Planning & Urban Development Department
Jeff Levine, Director

RE: Staff Review Comments for Preliminary Level II and Level III Site Plans

Project Name:	Pamela Road Extension/Subdivision Amendments	Project ID:	2013-097
Address:	Pamela Road	CBLs:	389-D-10, 11, 12, 13, 14
Applicant:	Telos Capital		389-E-2, 3, 4, 5, 6, 7
Planner:	Nell Donaldson

TYPICAL TRENCH SECTION DETAIL
NOT TO SCALE

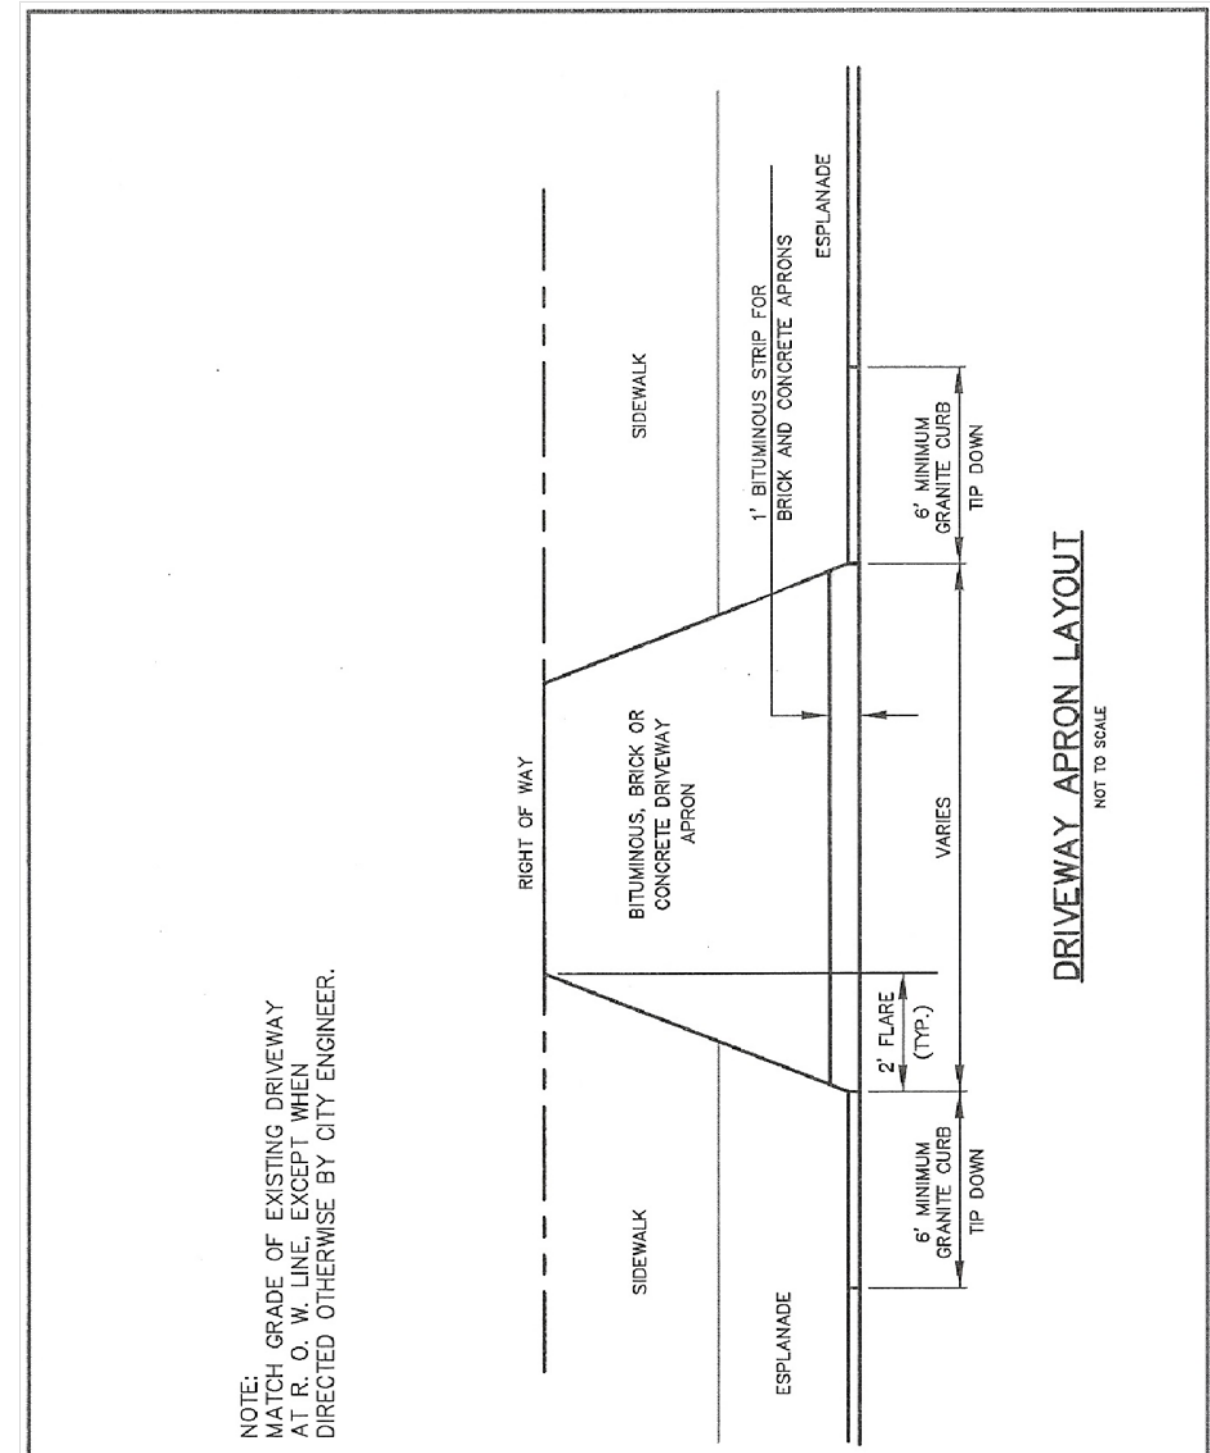
In accordance with Figure II-12 of the City of Portland Technical Manual, ¾" crushed stone in typical pipe trench installations shall extend 12-inches above the top of the pipe; the proposed detail specifies six inches. The Applicant should revise accordingly.

**TYPICAL HYDRANT INSTALLATION DETAIL**  
 NOT TO SCALE

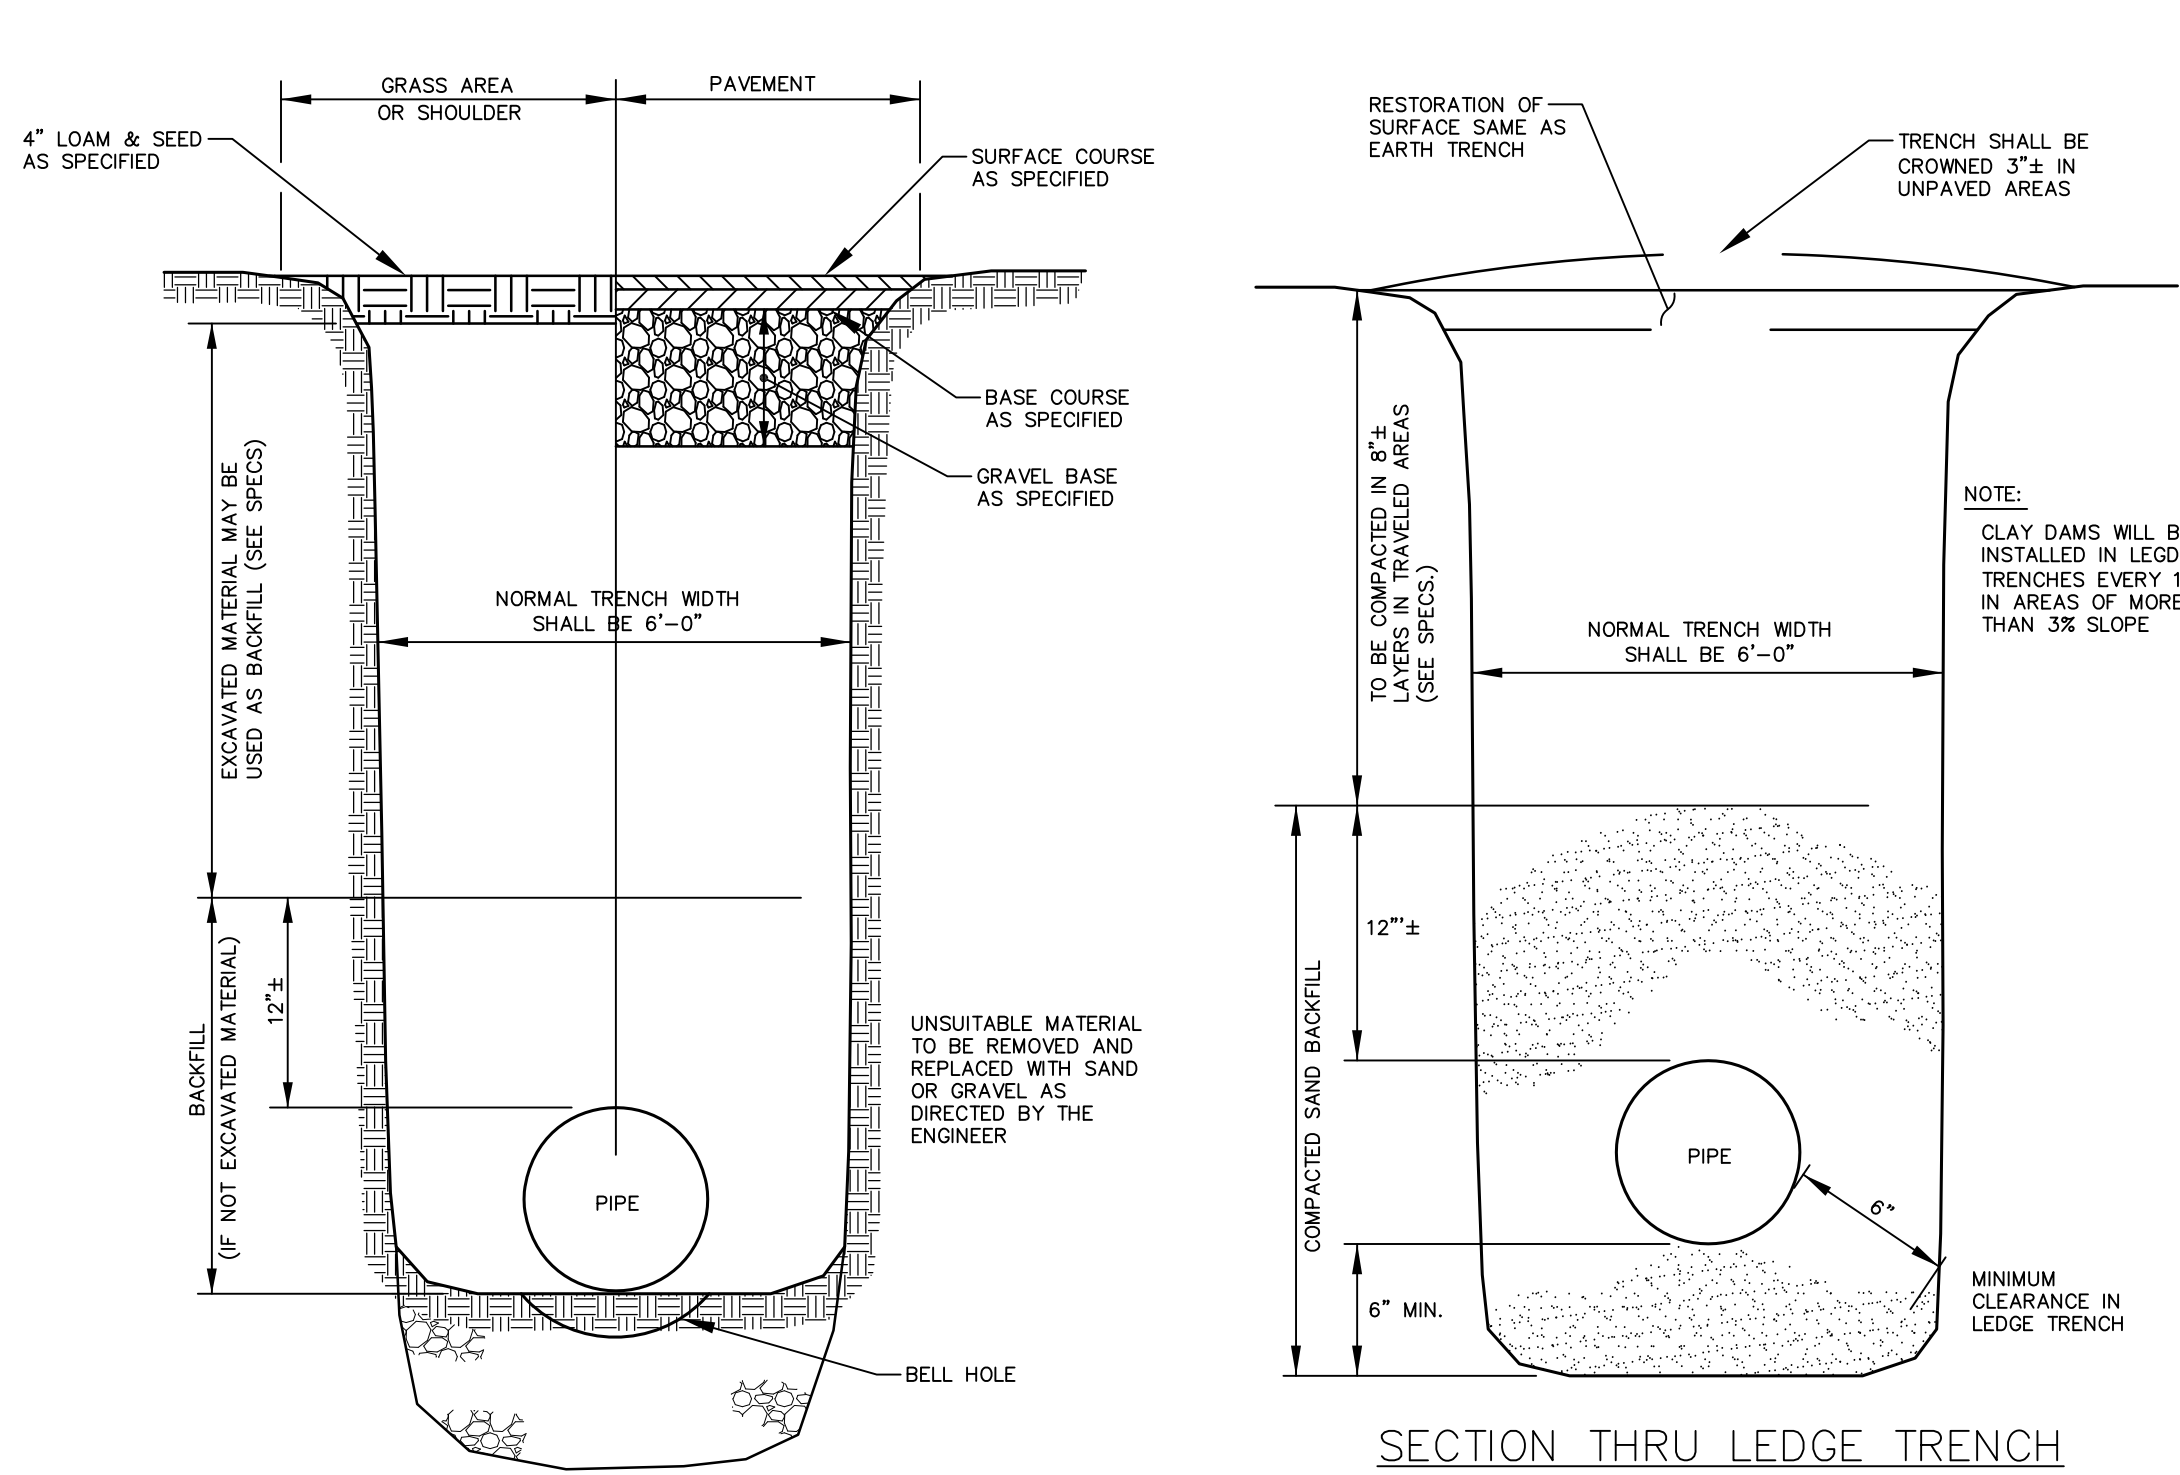
Our comments at this point are that the street needs hydrants, hydrants should be approximately 500 feet apart. There are two hydrants on Alice each approximately 700+/- from where Pamela Rd will intersect. There is also a hydrant around the corner on Abby Ln about 250 ft from Pamela, the next hydrant is up at Crestview.

Captain Petruccelli has provided a diagram, which is included as Attachment 2. Proposed hydrants should be added to the site plan.

PER MDOT ITEM 604.  
**PRECAST CONCRETE CATCH BASIN DETAIL**  
 N.T.S.

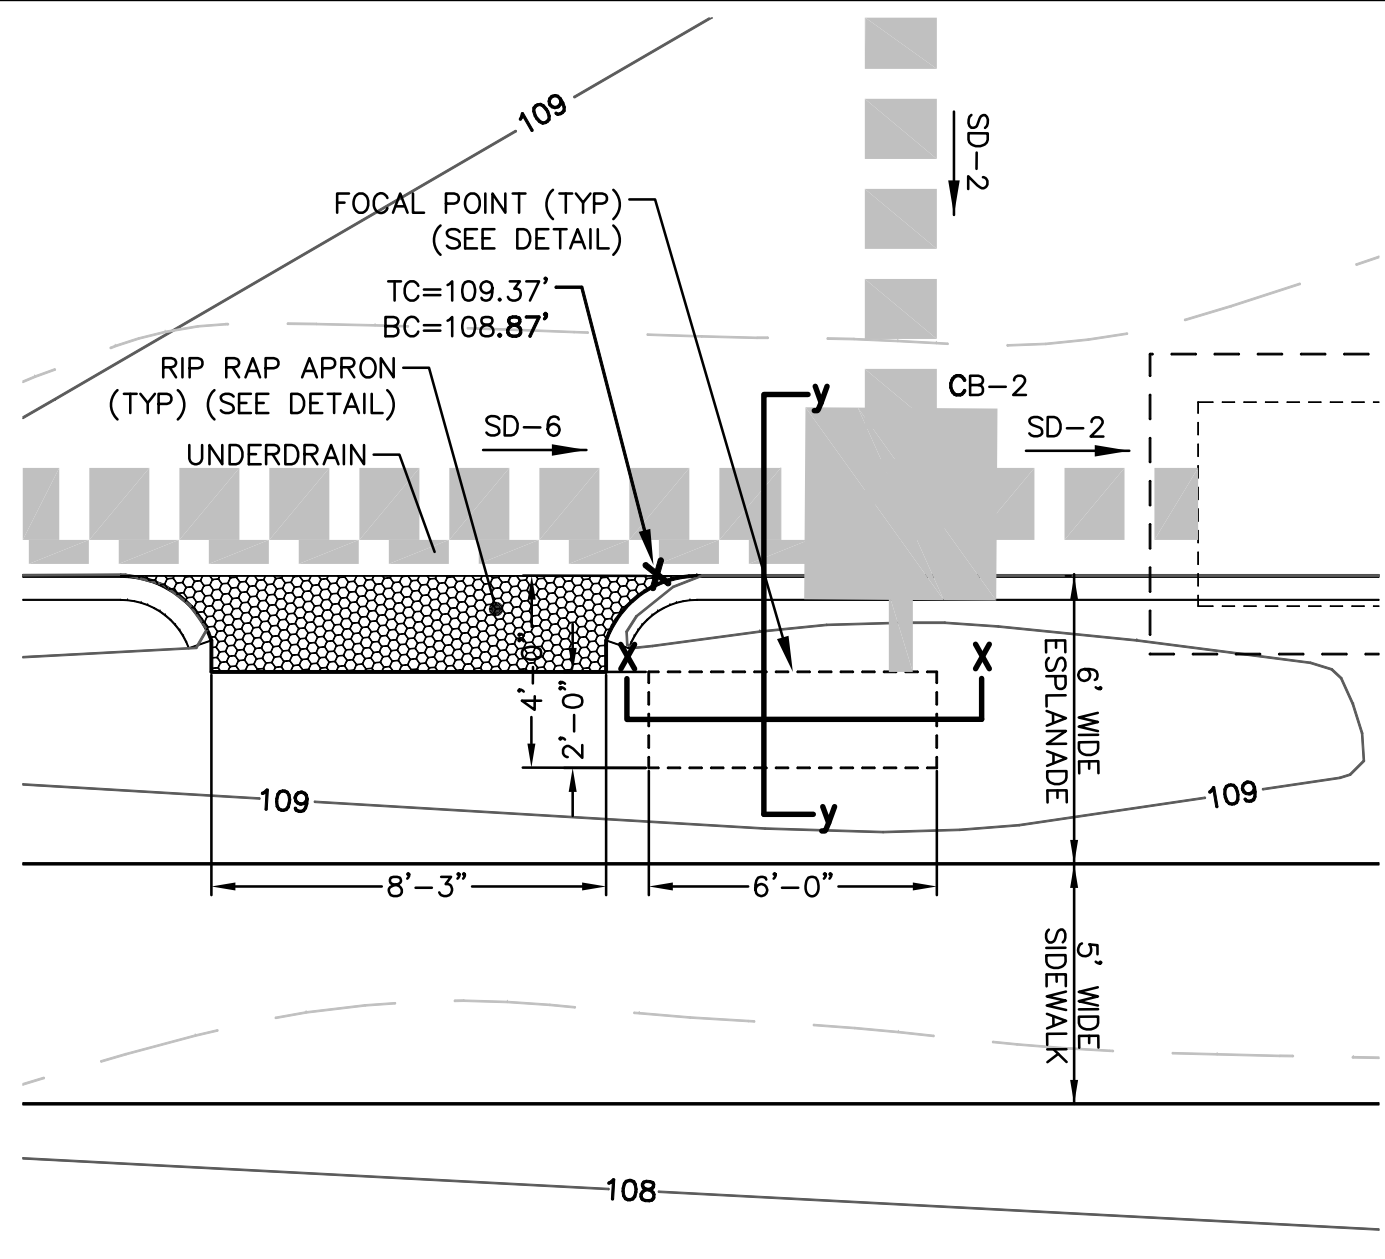
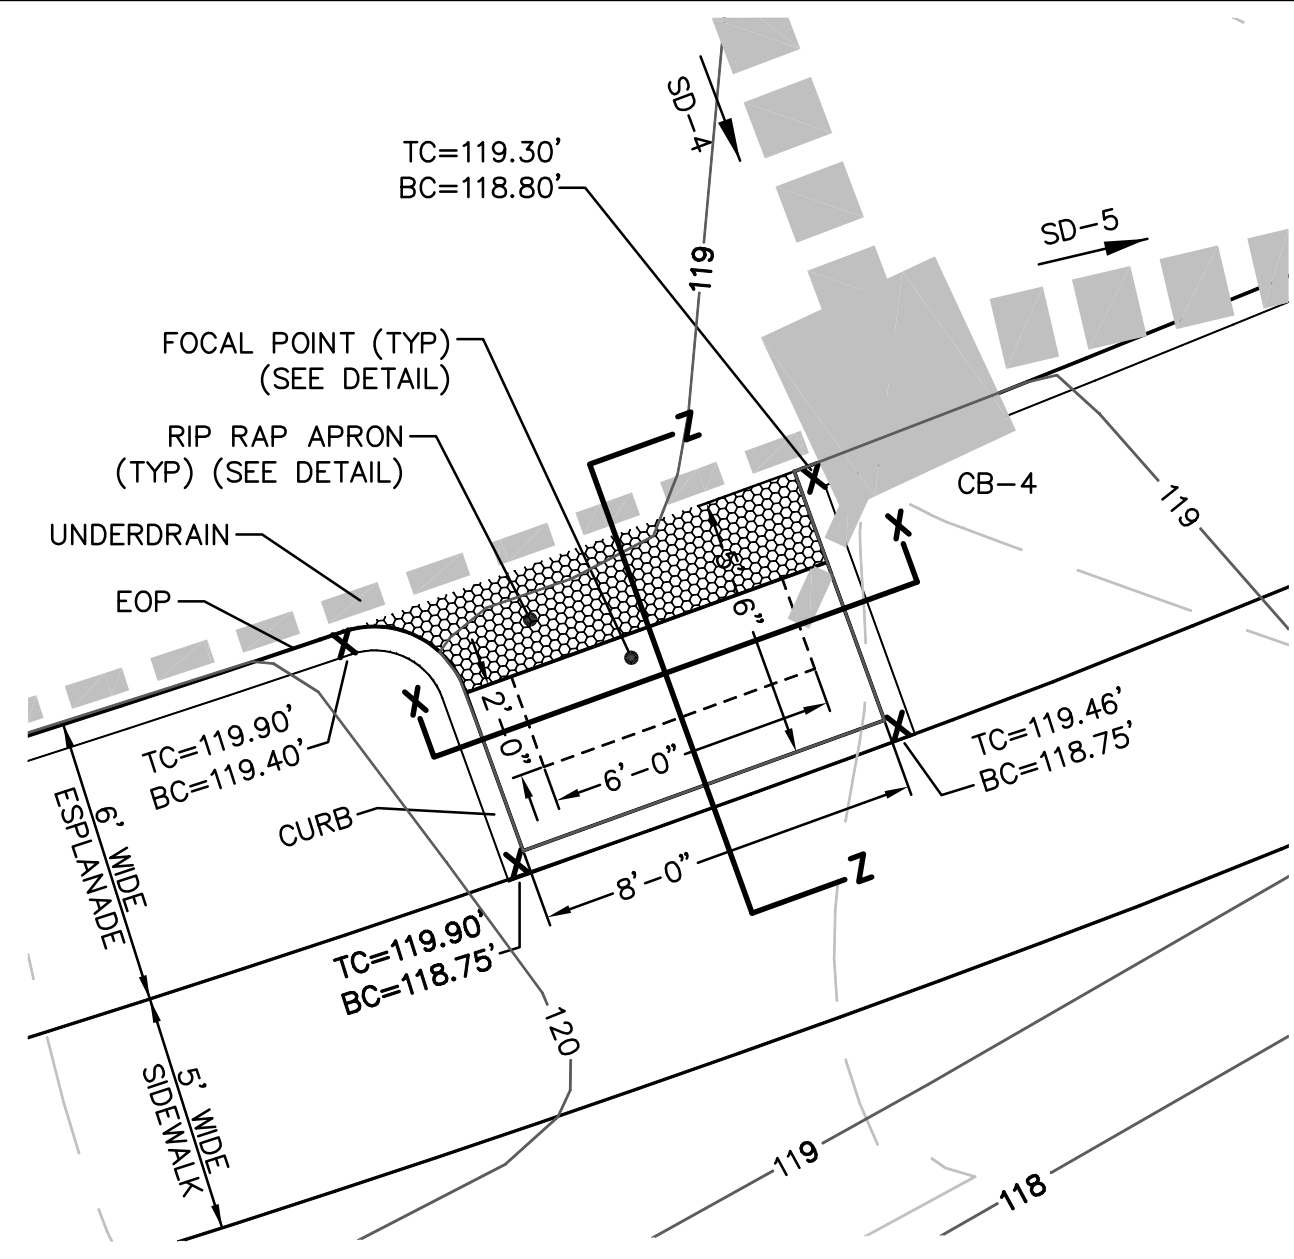
In accordance with Figure II-2 of the City of Portland Technical Manual, catch basins should have a minimum three foot sump; the proposed detail specifies two feet. The Applicant should revise accordingly.

The catch basin Frame and Grate detail on Sheet 10 of 11 does not meet City Standard; the City's standard is shown on Figure II-7 of the City of Portland Technical Manual. The detail should be revised accordingly.
